**Application no: 23/01133/DISC**

**Location:** Oxford Technology Park, Technology Drive, Kidlington, OX5 1GN

## **Transport Development Control**

### **Framework Travel Plan – Specific Points**

Site Layout
 Scale 1:500

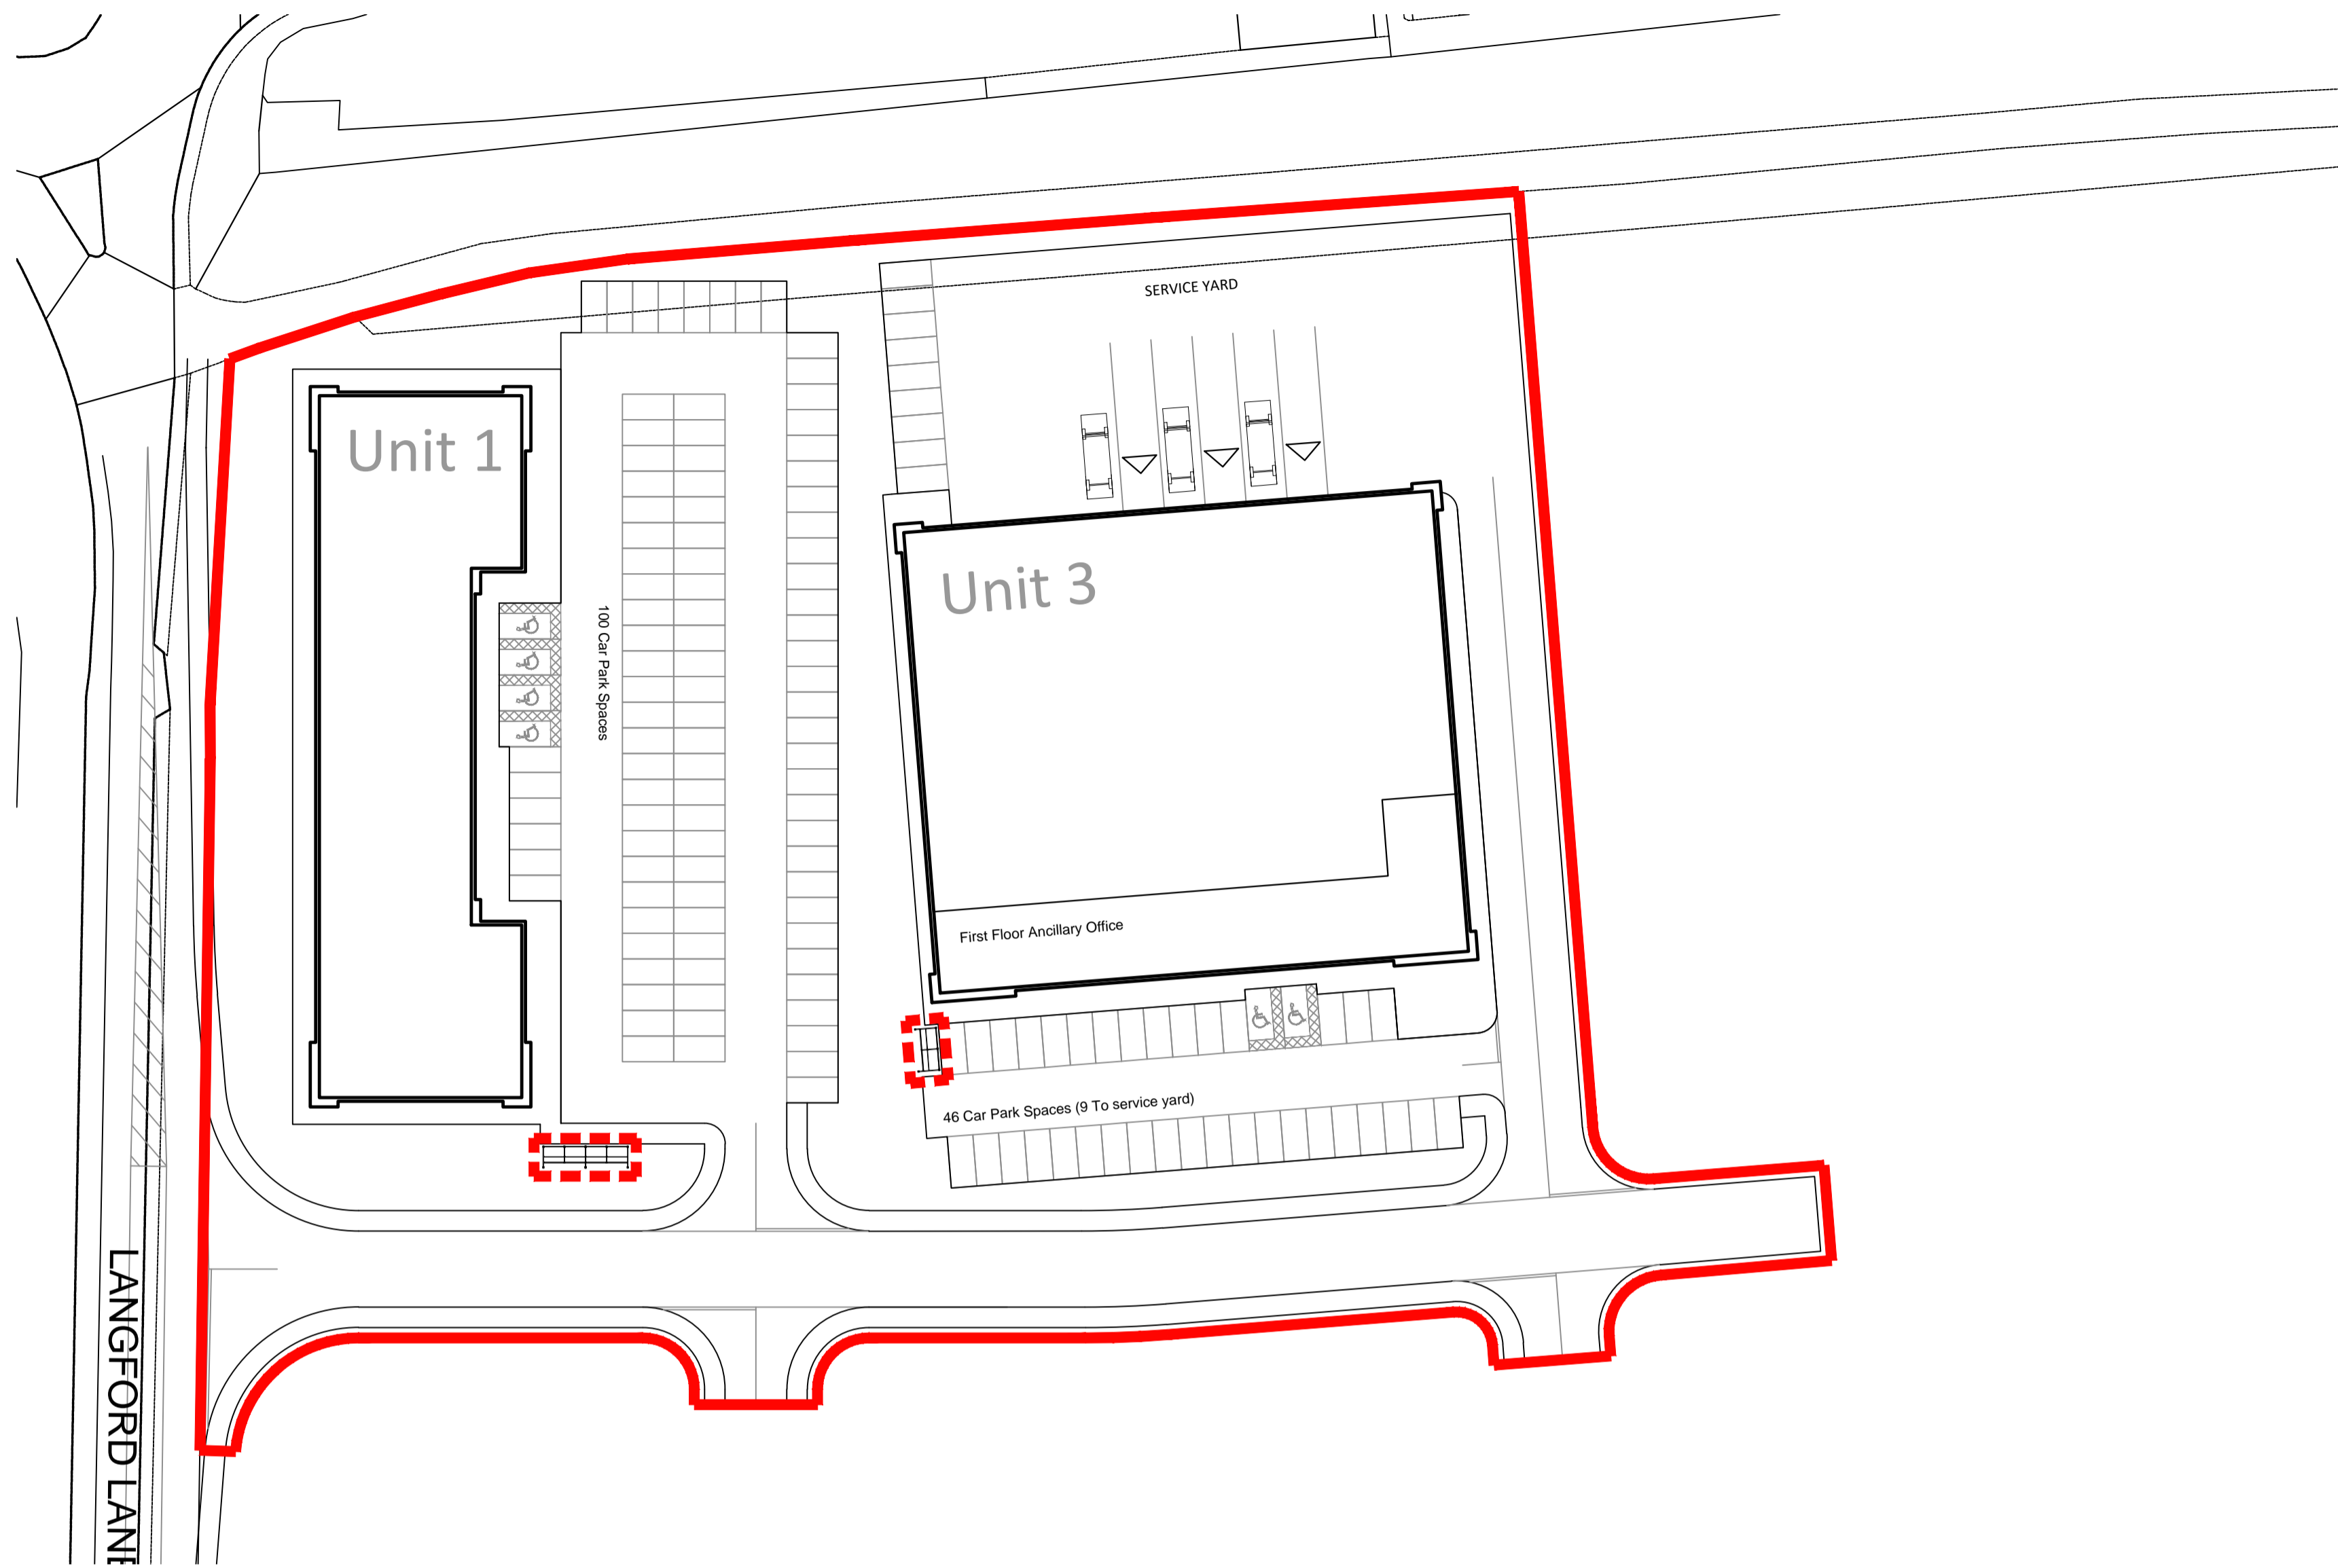
- What is the planned/ estimated date of occupation? From looking at the website it seems that the hotel may already be operating?
- The inclusion of a site plan is required.

- Further information about the onsite facilities for pedestrians, cyclists and vehicle users should be included. For example – Are there pedestrian facilities throughout the site – crossing points, lighting, dropped kerbs etc. How many cycle parking spaces will be provided? Will these be covered? Secure? How many car parking spaces will be provided? Will there be any designated car sharing spaces?
